Application # 0750018802R

COUNTY OF HARNETT LAND USE APPLICATION

Re: Status of Improvement Permit Application #07-5-18862
Nature's Crossroads Lt 44

SITE PLAN APPROVAL  
DISTRICT RAZOR USE SFD  
#BEDROOMS 3  
JP 11/29/07  
ZONING ADMINISTRATOR

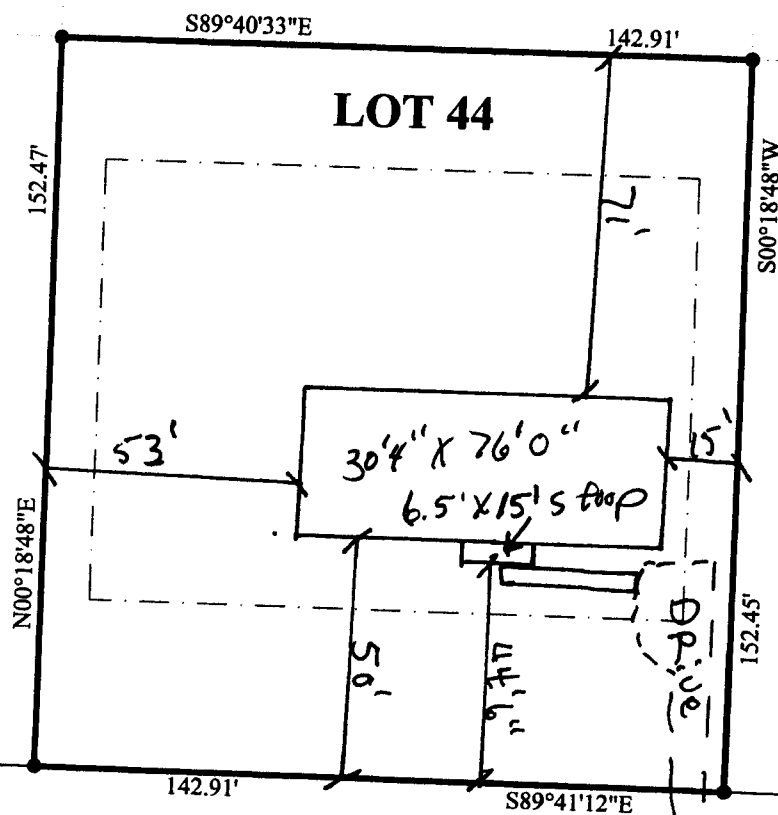
- 1. Property lines/corners not marked or labeled
- 2. House corners not marked or labeled
- 3. Directions not clear to property
- 4. Property needs brush or vegetation removed
- 5. Backhoe pits required
- 6. Other – Move house as shown and reduce to 3 bedrooms. Submit changes to Central Permitting.
